# Boston Alternative Energy Facility

## Statement of Common Ground between Alternative Use Boston Projects Limited and Boston Borough Council

Planning Inspectorate Reference Number: EN010095

Date: ~~February~~March 2022

Key	
	Order limits
	Land outside Order limits
	Slope Protection
	Public Right of Way
	EXISTING VEGETATION (Existing vegetation within site to be enhanced)
PROPOSED FEATURES:	
	NATIVE SPECIES WOODLAND
	SCATTERED SCRUB PLANTING
	INDIVIDUAL TREE / HEDGEROW TREE PLANTING
	SPECIES RICH GRASSLAND

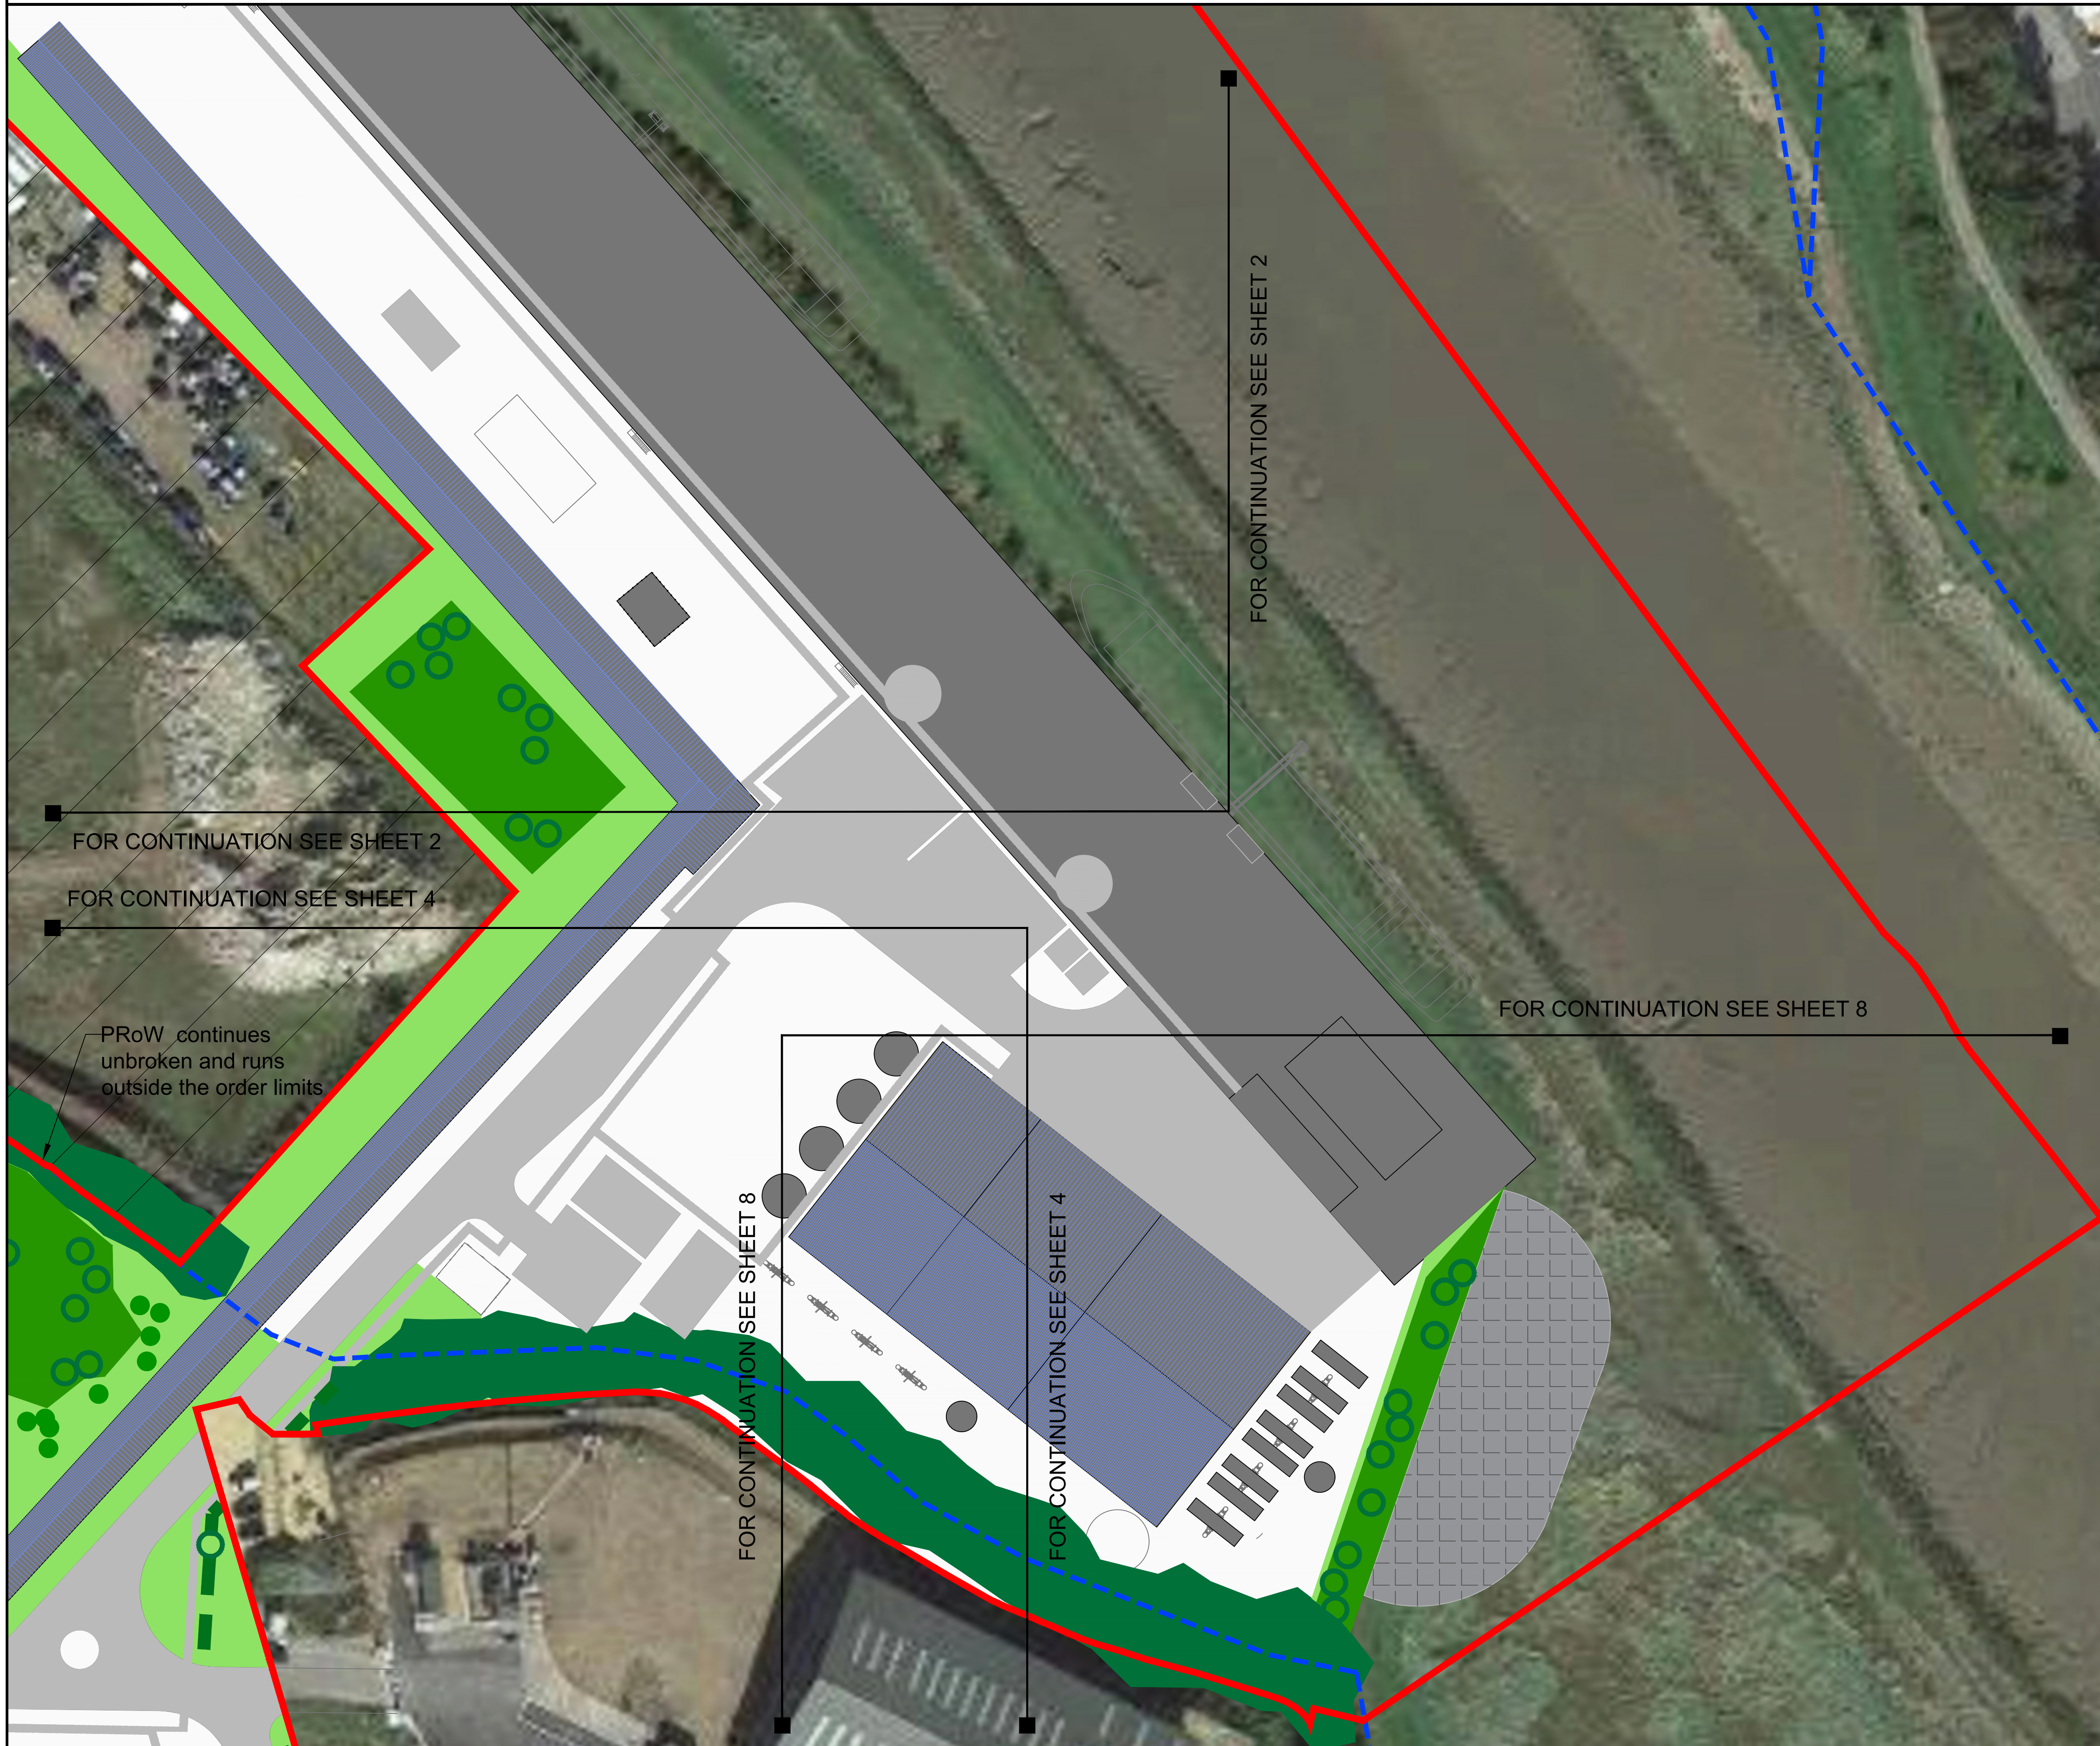
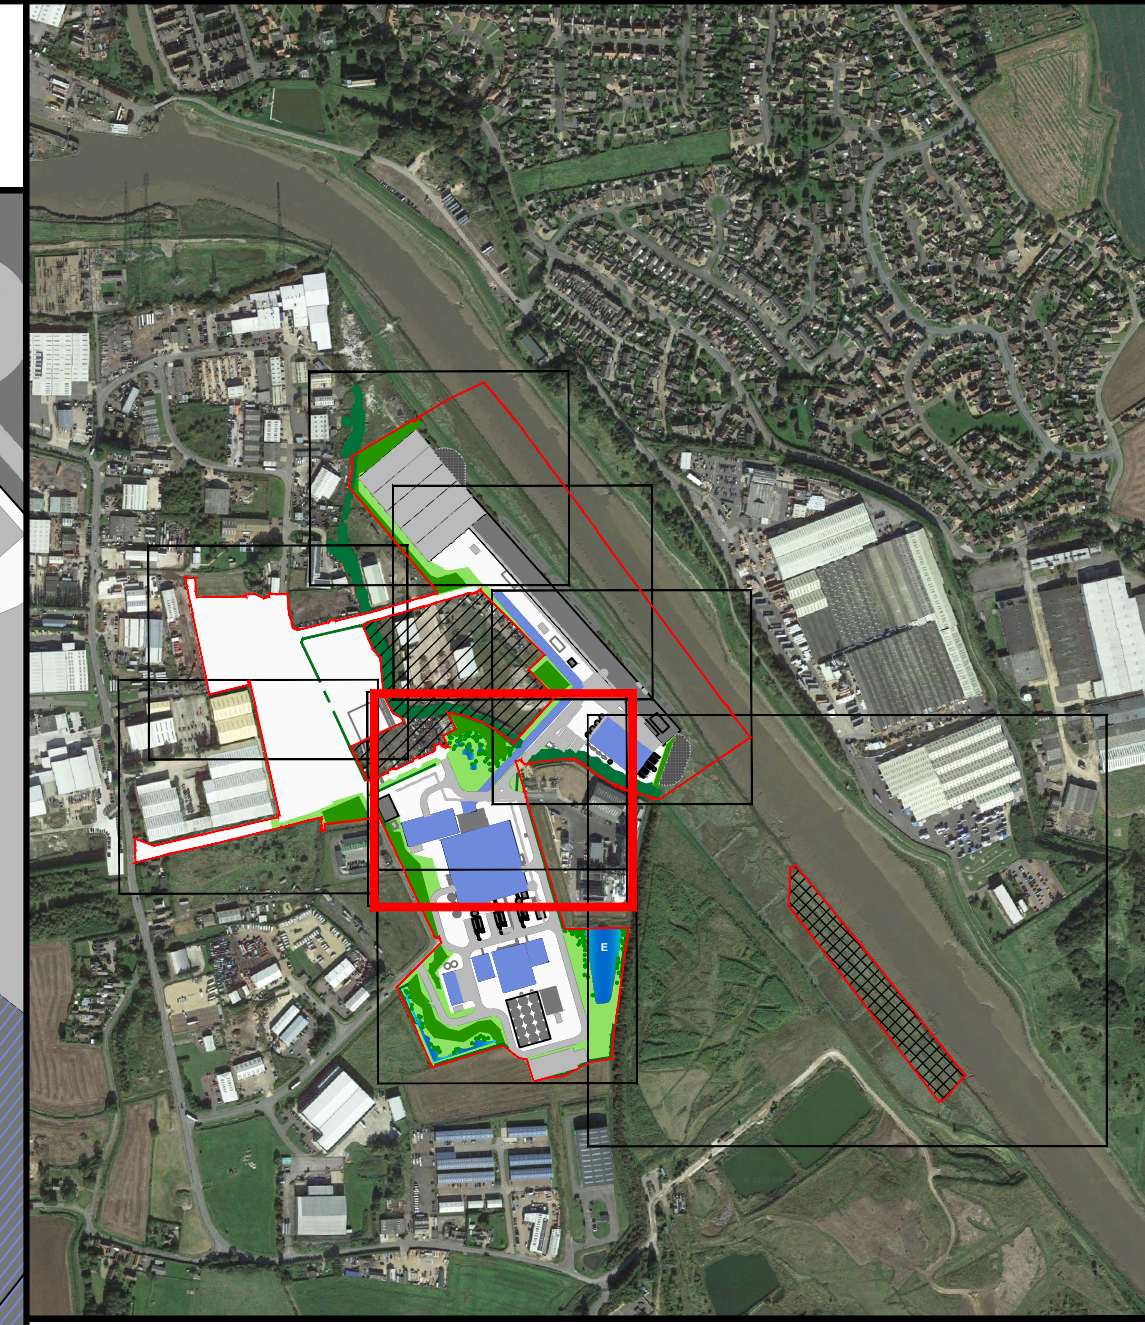
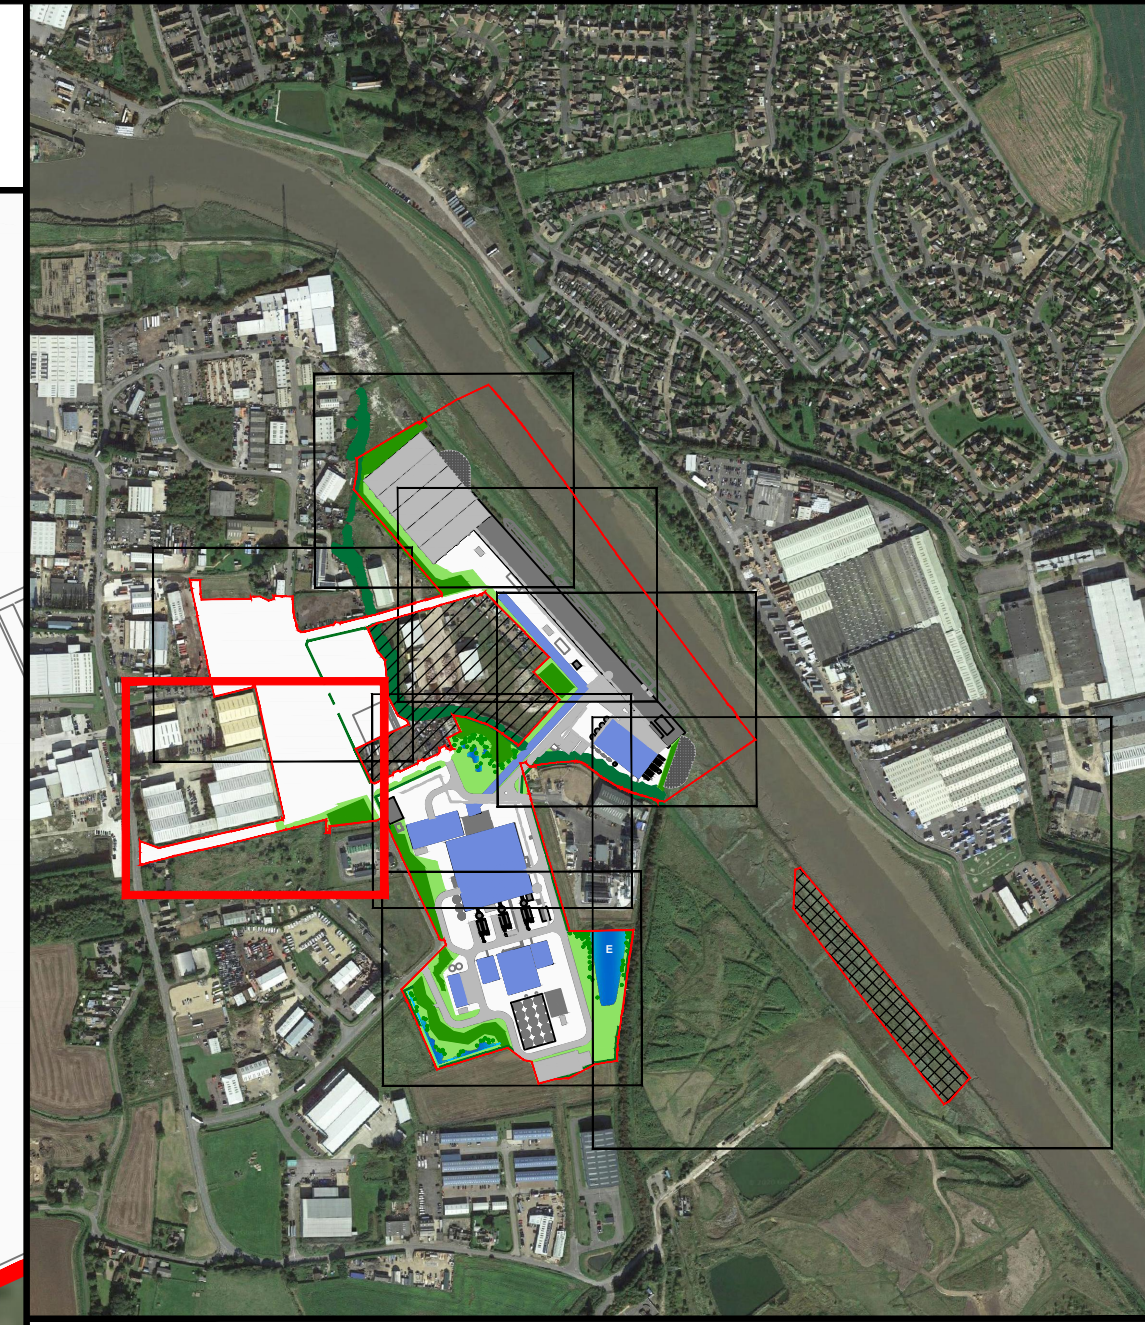
BBC 2.2	ES Chapter 9 ( <i>Landscape and Visual Impact Assessment</i> ) (doc ref 6.9.2, APP-047)	Landscape	<p>This development, as a result of its scale and form, will result in significant landscape and visual change. We note the embedded mitigation measures, but there is limited scope for other measures to reduce the impact of the structures themselves which are led by the technology proposed. We request</p>	<p>AUBP agrees with Boston Borough Council that due to the scale of the development further mitigation is not possible. However, AUBP has committed to providing interpretation of the facility (exact measures to be agreed) as part of the draft Section 106 agreement which is being discussed with Boston Borough Council <u>ad is in an</u></p>	Under discussion <u>pending conclusion of the s.106</u>

BBC 2.3	Outline Landscape and Ecological Management Plan (Doc ref 7.4, APP-123)	Biodiversity Net Gain (BNG)	<p>Further BNG opportunities should be explored at other local sites such as Woodland sites, nearby Local Wildlife Sites, Wildlife Trust sites Borough Council operated sites such as Witham Way Country Park, or in collaboration with the Eastern IFCA.</p> <p>The Council has reviewed the responses to date on this point. We note the steps taken by AUBP to</p>	<p>Terrestrial BNG is included within the Application where on-site planting is proposed. The focus on BNG is otherwise directed towards intertidal habitat loss. Therefore, the Applicant is considering BNG at Havenside Local Nature Reserve (LNR) as discussed in the updated Outline Landscape and Ecological Mitigation Strategy (OLEMS) <u>the latest version was submitted at Deadline 7</u> (document reference 7.4(24),</p>	<p>Under discussion <u>pending conclusion of s.106</u></p>

SoCG Reference	Document Reference	Topic	BBC's Position	AUBP's Position	Status
			undertaken in accordance with BS5837 standards, and that in the event trees are required to be felled or removed, appropriate mitigation planting should be provided.	under Requirement 6 of the draft DCO (document reference 2.1(42), REP83-0043). An <u>updated version of the</u> Outline Landscape and Ecological Mitigation Strategy (document reference 7.4(2), APP-123REP7-037) was submitted with the application at Deadline 7, which details the proposed procedures in relation to site clearance and proposed planting. The Illustrative Landscape Plans (document reference 4.4, APP-014) show the locations of proposed planting.
